KIRKLEES METROPOLITAN COUNCIL INVESTMENT & REGENERATION SERVICE

Reference No:	2023/62/93085/W
Site Address:	15, Highfields, Shaw Lane, Holmfirth, HD9 2PZ
Description:	Erection of rear dormer, porch and associated external alterations
Recommending Officer:	Joanna Rednall

HOUSEHOLDER DELEGATED REPORT

Application Number	2023/93085
Location	15 Highfields, Shaw Lane, Holmfirth, HD9 2PZ
Proposal	Erection of dormer, porch and associated alterations
Publicity end date	8 th December 2023
Number of representations received	None received
Kirklees Local Plan Allocation/Designation	Holme Valley Neighbourhood Area
Extension to Time (EoT)	No
Recommendation	Conditional Full Permission

Proposed Elevations

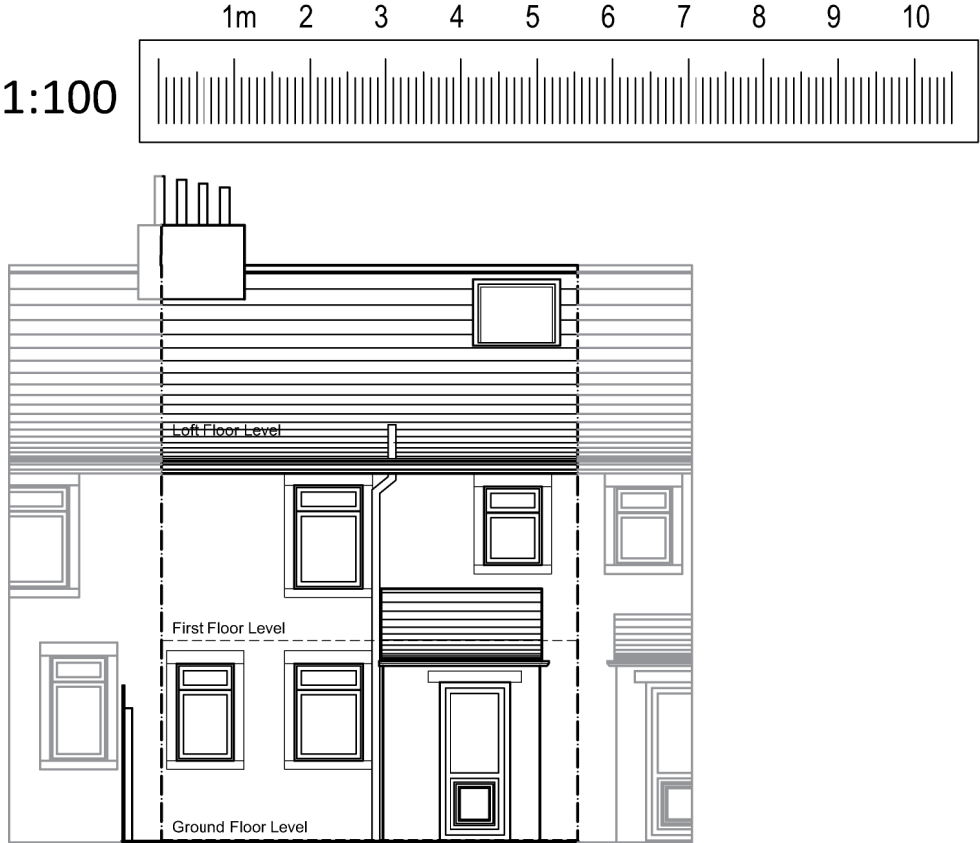
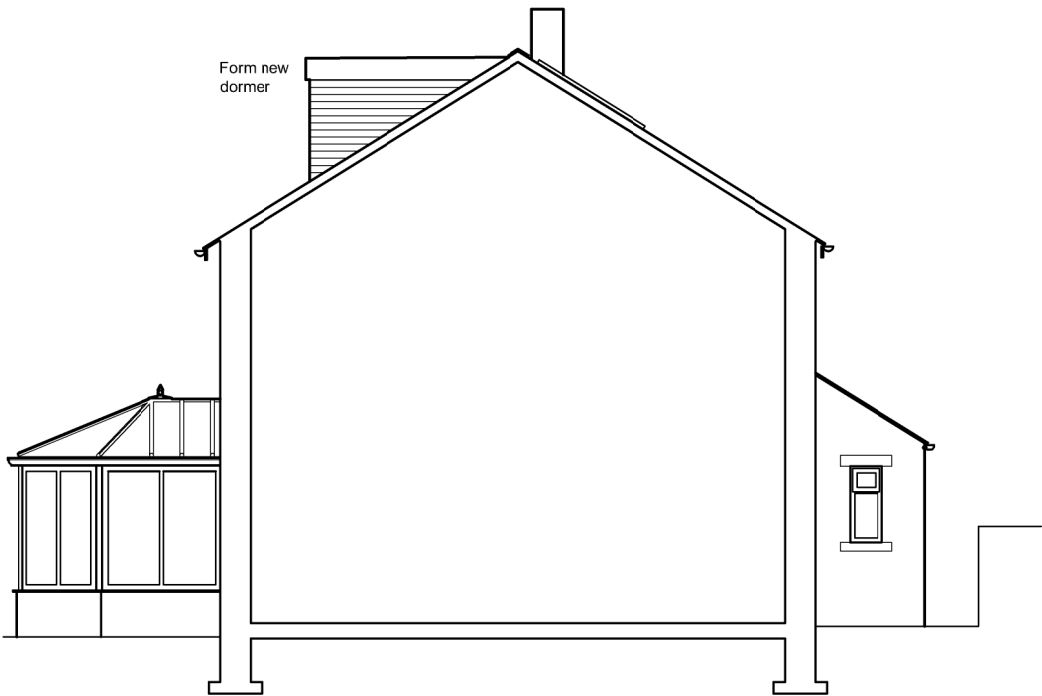
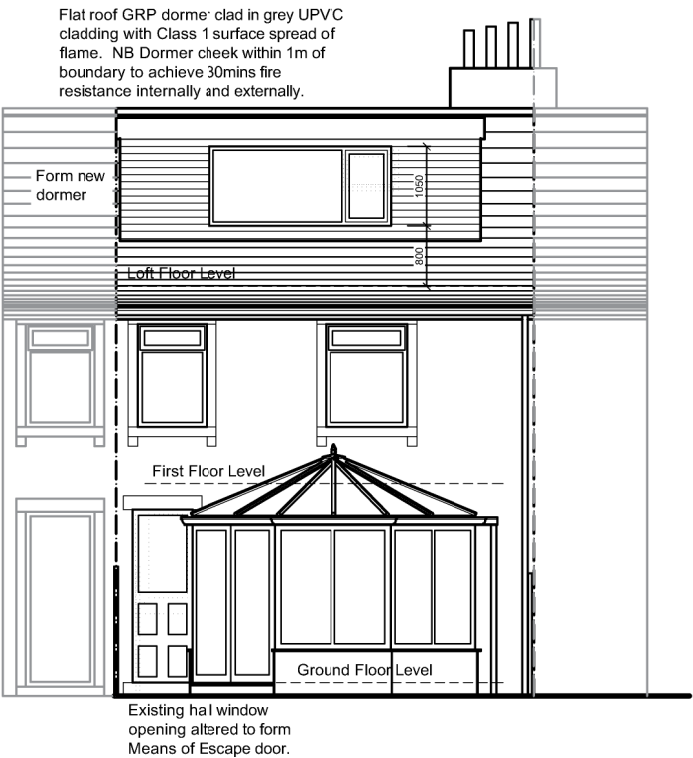
Permission is sought for the erection of rear dormer, porch and associated alterations. The dormer would have a total height of ~1.7 metres and a length of ~4.8 metres with a flat GRP roof. The dormer would project ~2.7 metres from the ridge of the roof. The porch (retrospective) would project ~1.4 metres from the front of the property with a width of ~2 metres. The height of the eaves would be ~2.4 metres with an overall height of ~3.3 metres to the ridge of the lean-to roof. Some other minor alterations are proposed to the conservatory to provide escape doors.

Dormer extensions should:	<u>Yes - COMPLY</u>	<u>No - JUSTIFY</u>
Relate to the appearance of the house and existing roof		No- it is a flat roofed dormer within the rear roof slope of the dwelling. However, significant weight is afforded to the pd fallback position for a dormer of this size in the rear roof slope.
Be designed in style and materials similar to		No – the dormer roof would be GRP with grey

the appearance of the existing house and roof		UPVC cladding, not tiled in red but can be secured in a condition to be dark grey.
Not dominate the roof or project above the ridge of the house	Yes – the dormer does not project above the ridge or extend to full depth or width of the roof. It would be ~0.3 metres below the ridge of the roof.	
Be set below the ridge line of the existing roof and within the roof plane	Yes – the dormer would be below the existing ridgeline and within the roof plane.	
Be aligned with existing dormer windows on neighbouring properties in the same roof plane where relevant		No - there are no other rear dormers on neighbouring properties however the property has full Permitted Development Rights which would be a likely fallback in this case.

Relevant key design principle (KDP) and HVNDP of the SPD, Policy in the Kirklees Local Plan and the NPPF	Further comments	✓ / X / N/A
Impact on the Local character and street scene	• KDP1 of the SPD • Policy LP24 Design (a) and (c) of the KLP • Policy 1 & 2 of the HVNDP • Chapter 12 NPPF	The dormers would be an interruption to the roof slope however the property has full PD rights intact. The porch is a subservient addition which has no material impact on the streetscene.	✓
Impact on original house	• KDP2 of the SPD • Policy LP24 Design (c) and (d) of the KLP • Policy 1 & 2 of the HVNDP • Chapter 12 of the NPPF	Original roof would still be visible around the dormer within the rear elevation, to an acceptable extent taking into account the fallback position.	✓
Height, scale and massing	• KDP 1 and 2 of the SPD • Policy LP24 Design (a), (c) and (d) of the KLP • Policy 1 & 2 of the HVNDP • Chapter 12 of the NPPF	The dormer would be ~1.7 metres in height and have a length of ~4.8 metres. it would project ~2.7 metres from the ridge of the roof, at its greatest extent. Taking the pd fallback into account, the dimensions are not excessive. The porch is a small and proportionate addition to the front elevation	✓

Facing materials and detailing	• KDP 9 of the SPD • Policy LP24 Design (d) (iii) of the KLP	Dark Grey UPVC cladding to the dormer– can be secured by a condition.	✓

Summary of Representation	Officer response	Addressed ✓ / X / N/A
Holme Valley Parish Council – oppose - Materials are not in keeping with the surrounding area. - Insufficient parking for an increased dwelling size	The materials for the dormer, taking into account the realistic fallback position for this feature, are accepted: provided these are dark grey. The number of bedrooms would not change as a result of the proposal, the internal accommodation would be re-organised and an existing bedroom removed to create the stairway to the attic bedroom.	✓

3. The face and cheeks of the hereby approved dormer extension shall be either vertically slate hung with slates that in all respects match those used on the existing roof or be clad in dark grey cladding as set out within the application form. The materials of construction shall thereafter be retained.
